**SECTION 75W APPLICATION TO MAJOR PROJECT APPLICATION NO. 10\_0057 FOR  
RESIDENTIAL DEVELOPMENT AT 132-138 KILLEATON STREET, ST IVES (LOT 2, DP 748682) –  
REDUCTION OF BASEMENT CAR PARKING**

Pursuant to Section 75W(1)(a) of the Environmental Planning and Assessment Act, 1979, a "Modification of Approval" is sought to modify the number of visitor car parking spaces. Consent is therefore sought to vary Conditions B12(a) and B1A(f) of MP10\_0057.

DRAWING TITLE:
CARPARK PLANS

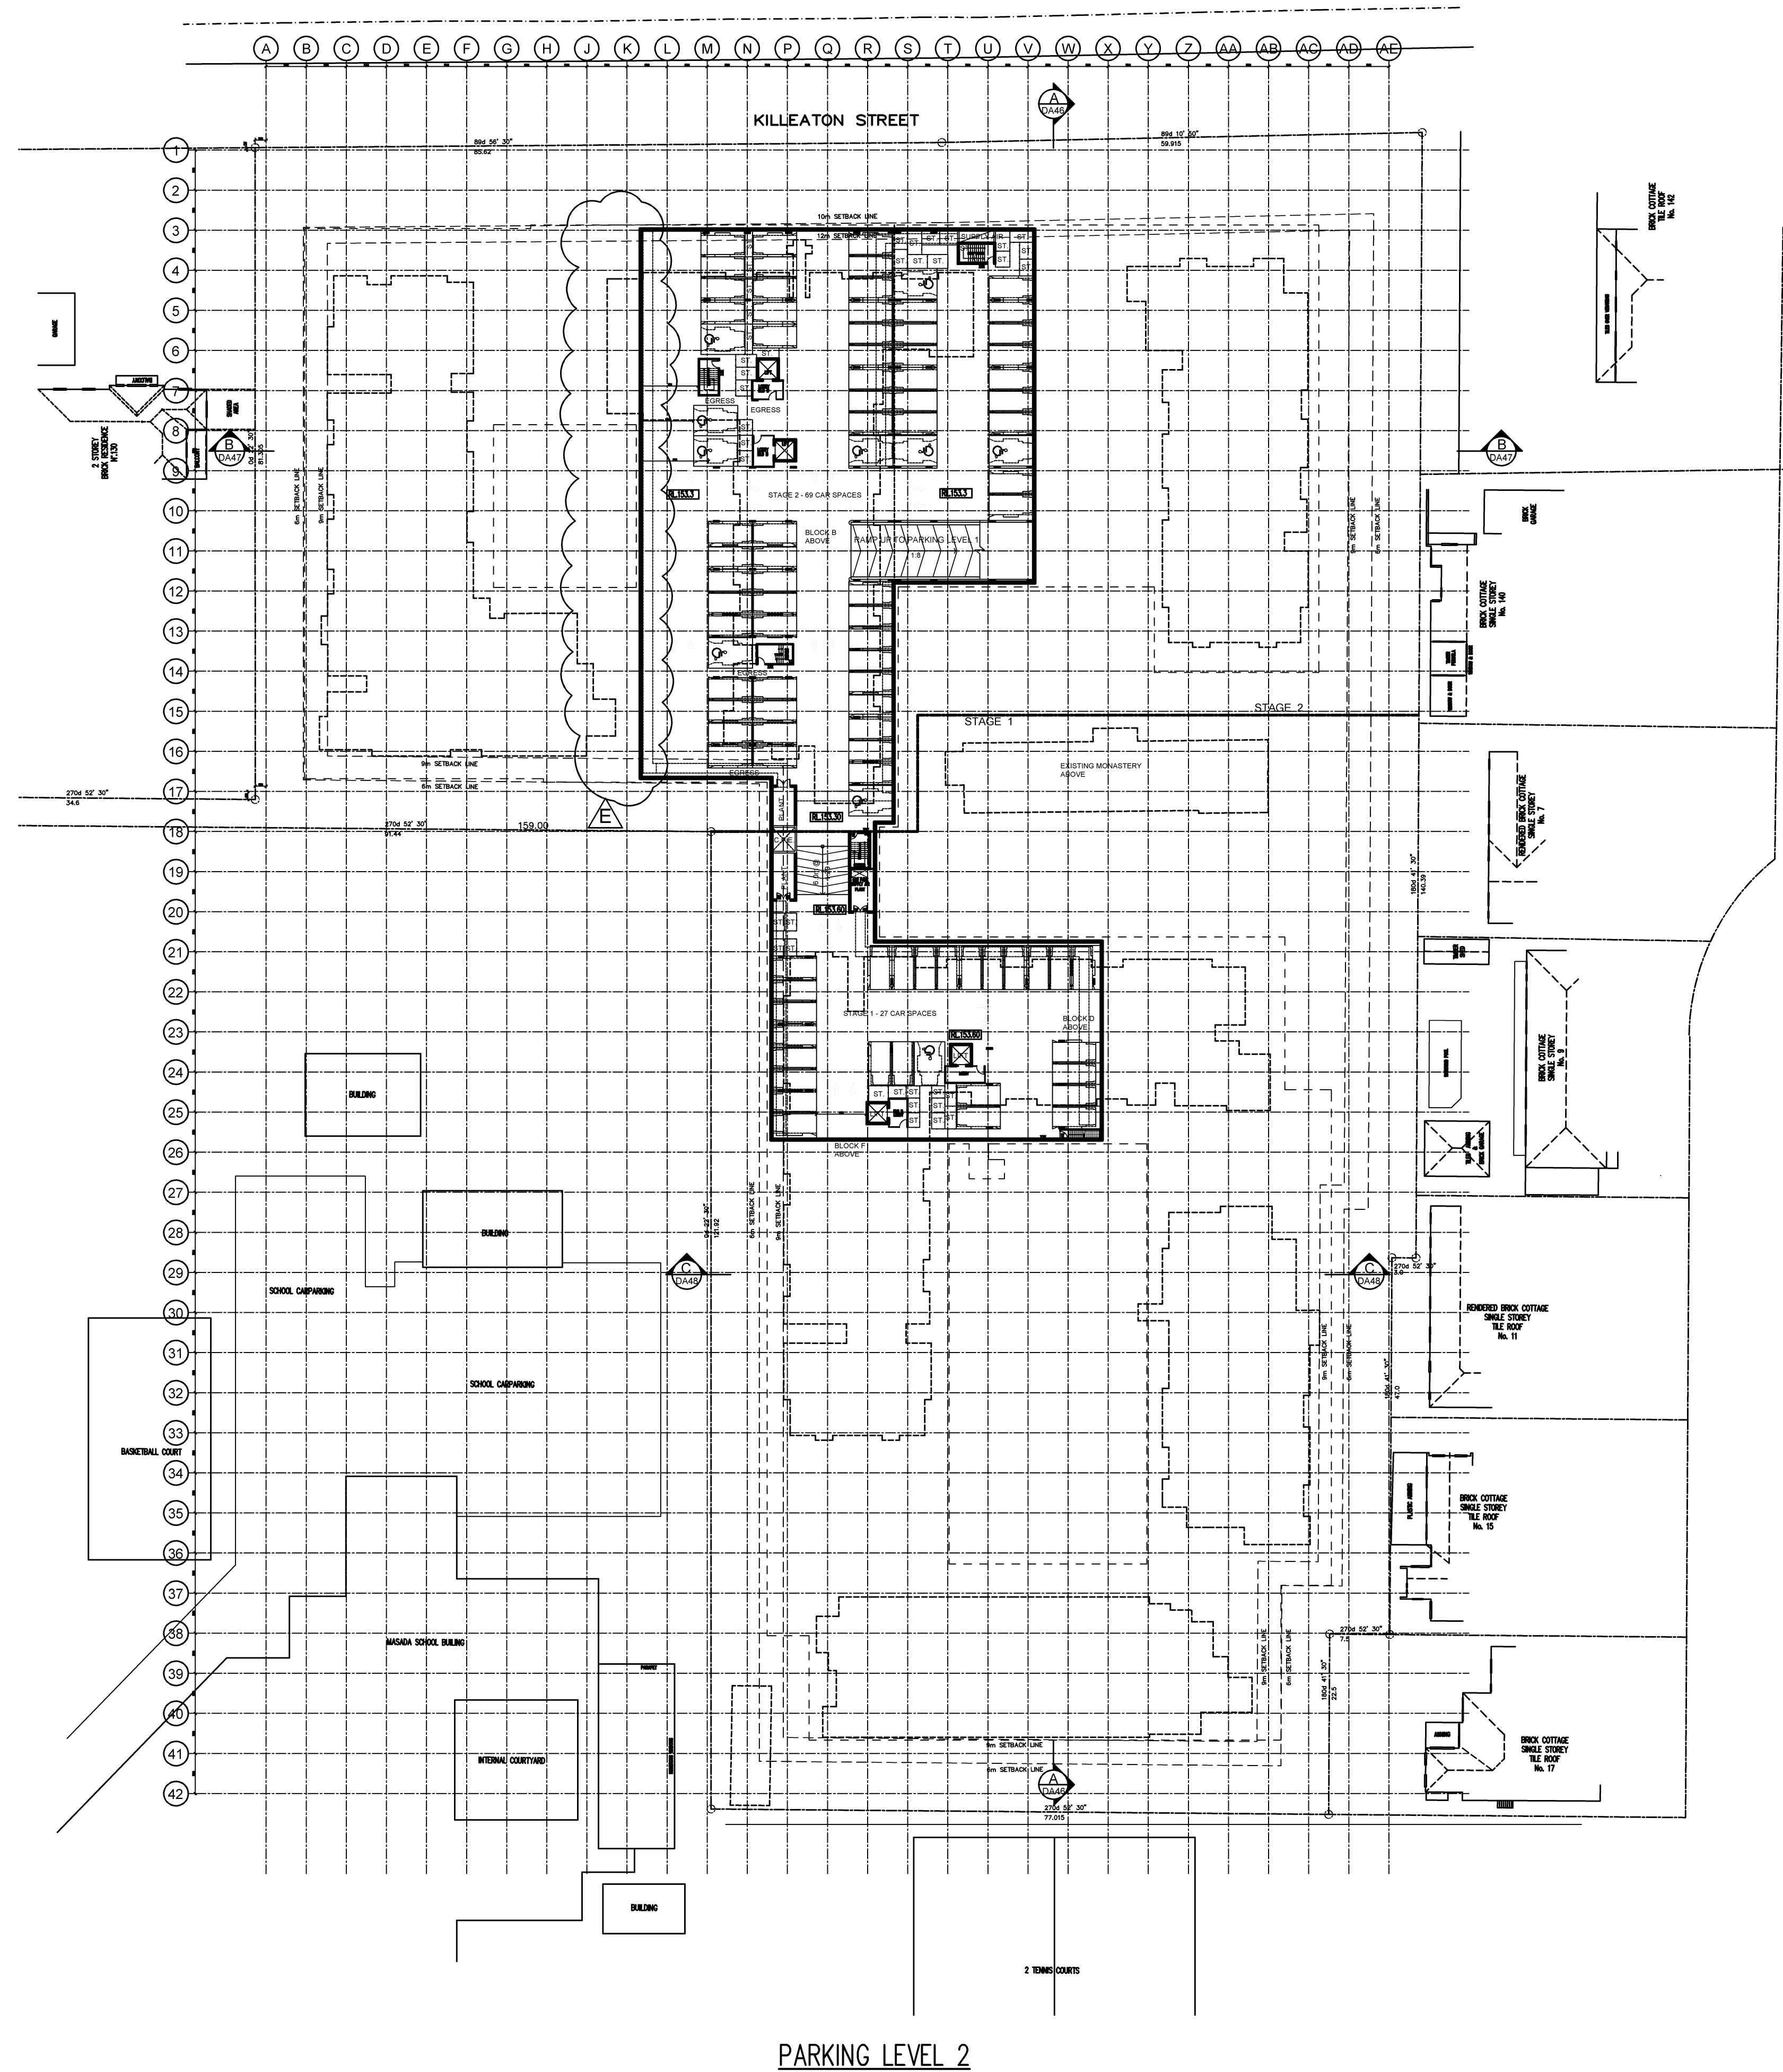
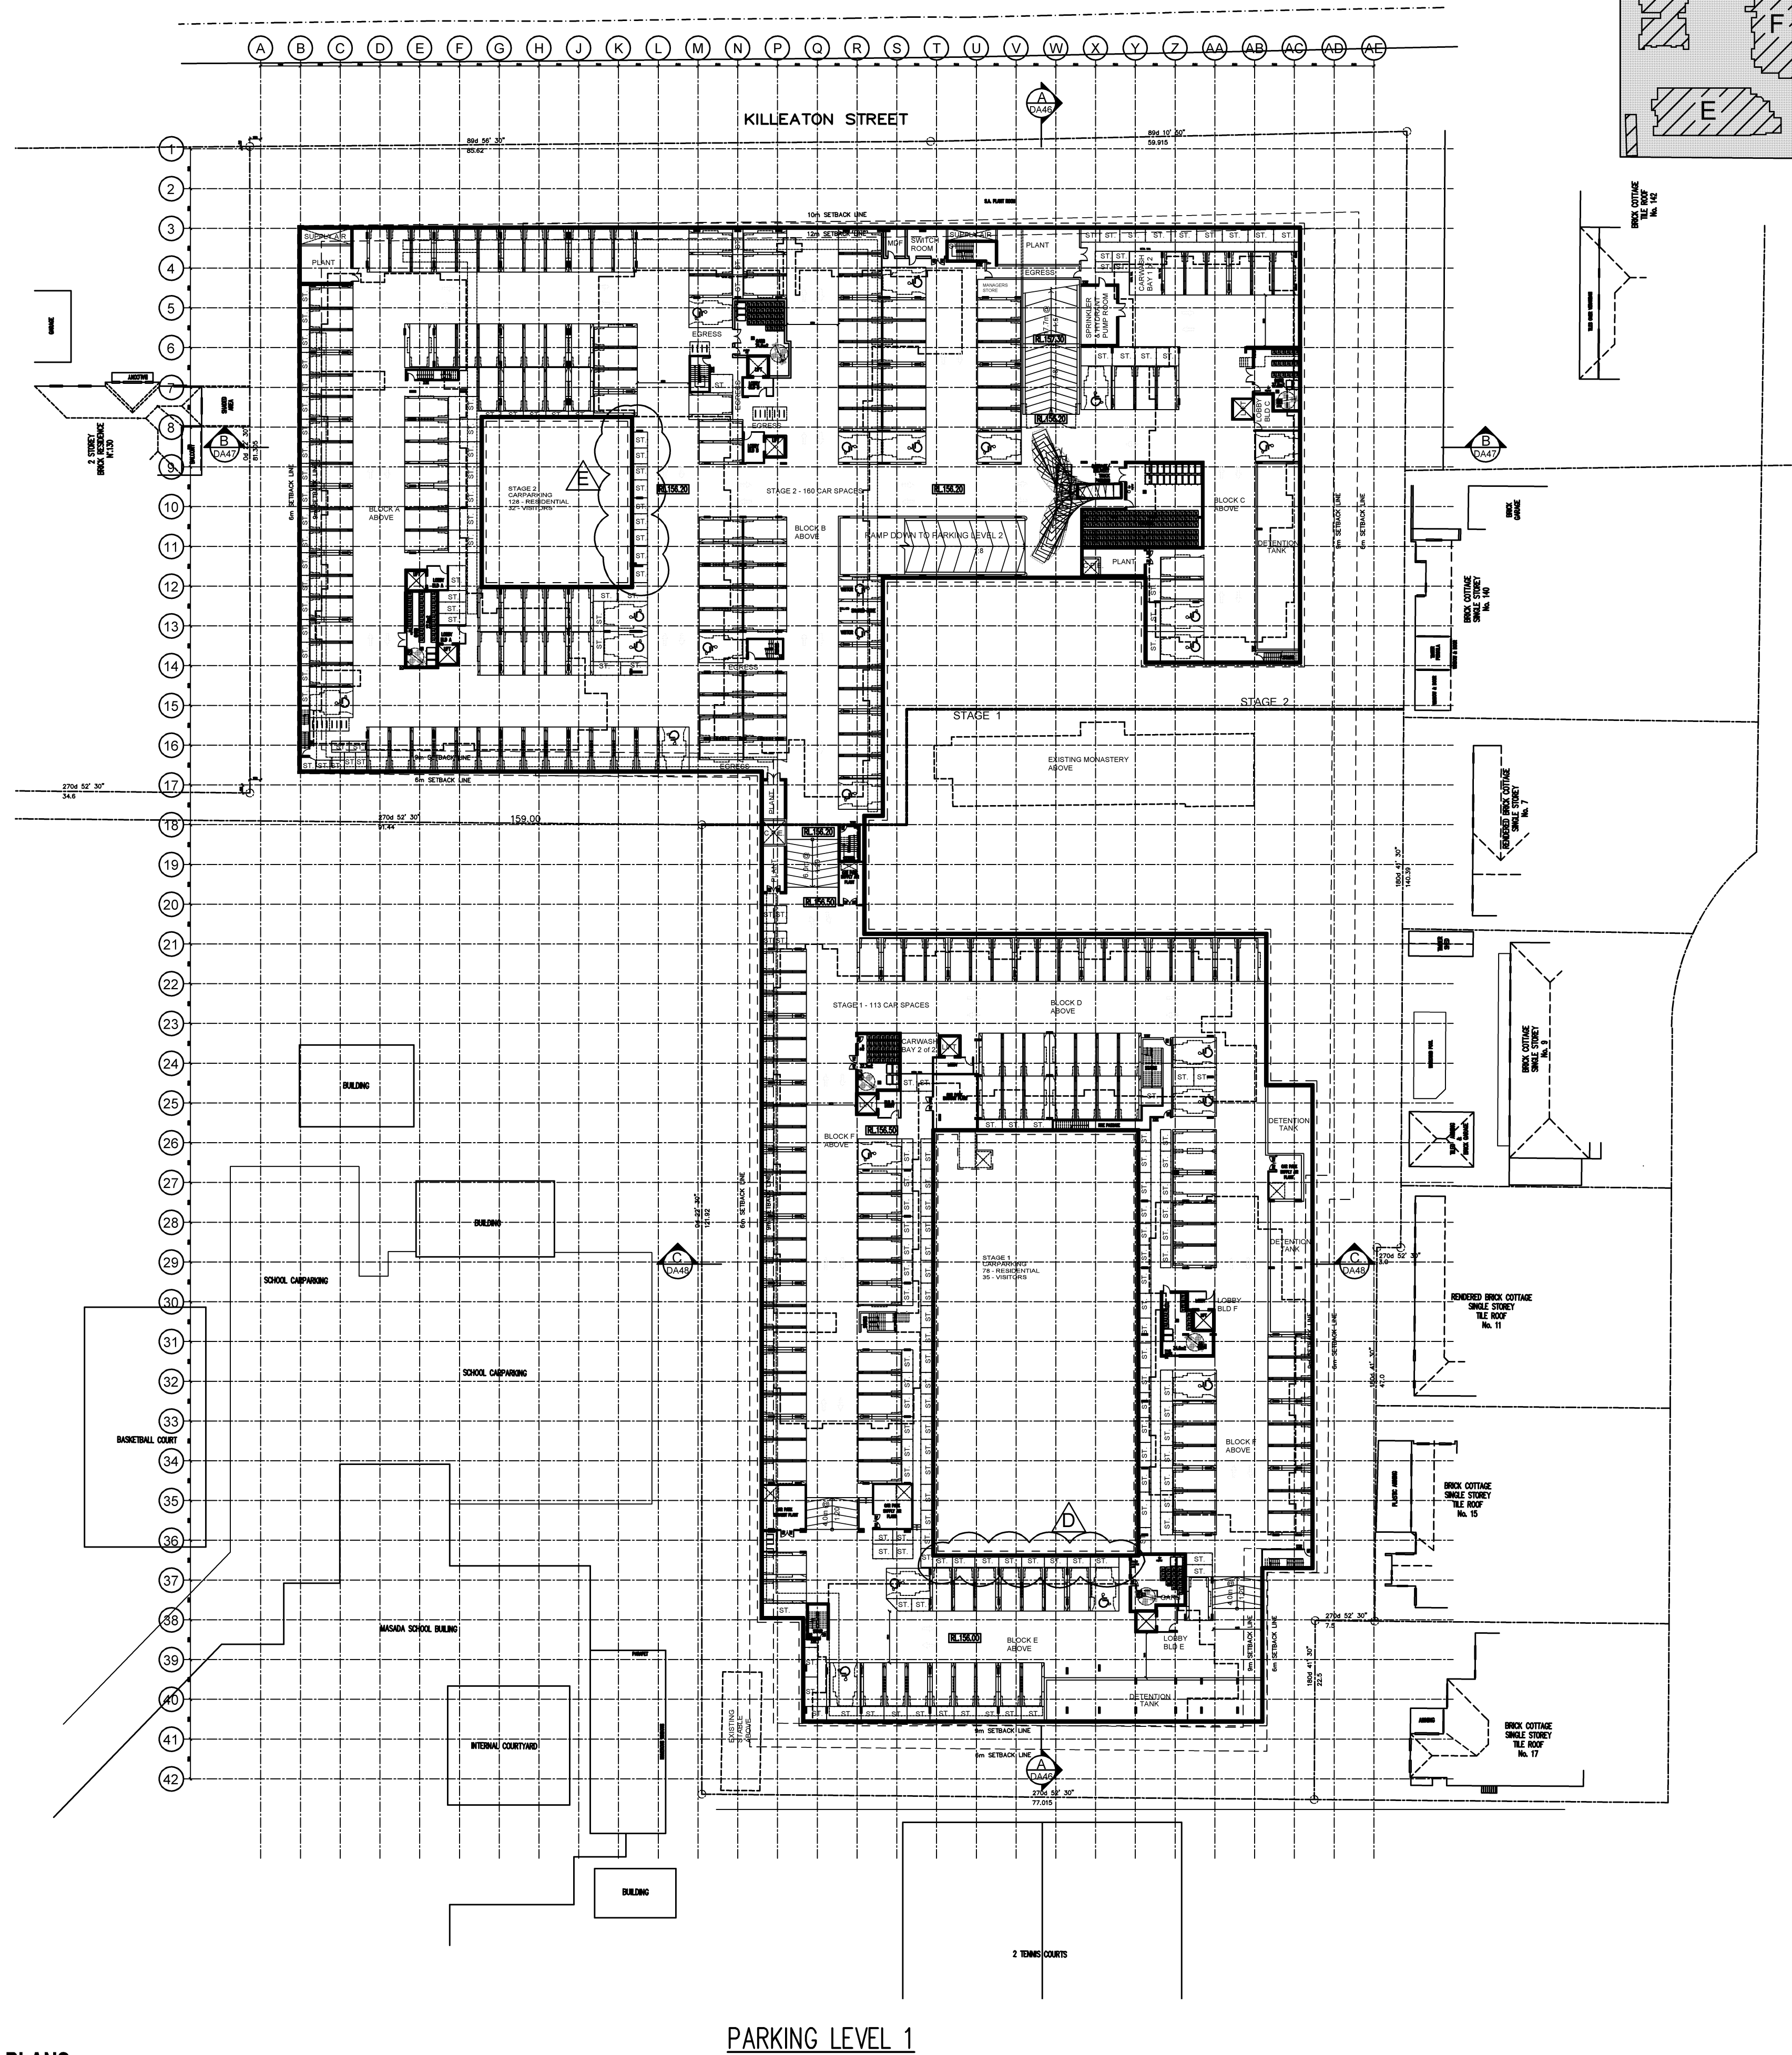
1. Modify the number of visitor car parking spaces.

Given that the basement is currently under construction, there is only the ability to reduce the number of visitor parking spaces. Halcrow Traffic consultants have reviewed the visitor car parking and a report is contained in **Annexure 2**.

The reduction in the overall footprint of the basement car park will create more deep soil open space for future residents. The deep soil area has been increased from 40.1% to 40.4%.

- a. ~~Parking must be provided in accordance with the requirements for visitor and residential parking in the Kuring-gai Development Control Plan (Town Centres) 2010. **A total of 369 car parking spaces are to be provided within the basement, including a minimum of 48 visitor parking spaces.** Visitor parking shall include a minimum of 2 spaces designated for persons with a disability. The design and construction of the parking area and parking spaces must be in accordance with AS2890.1 and AS2890.6.~~
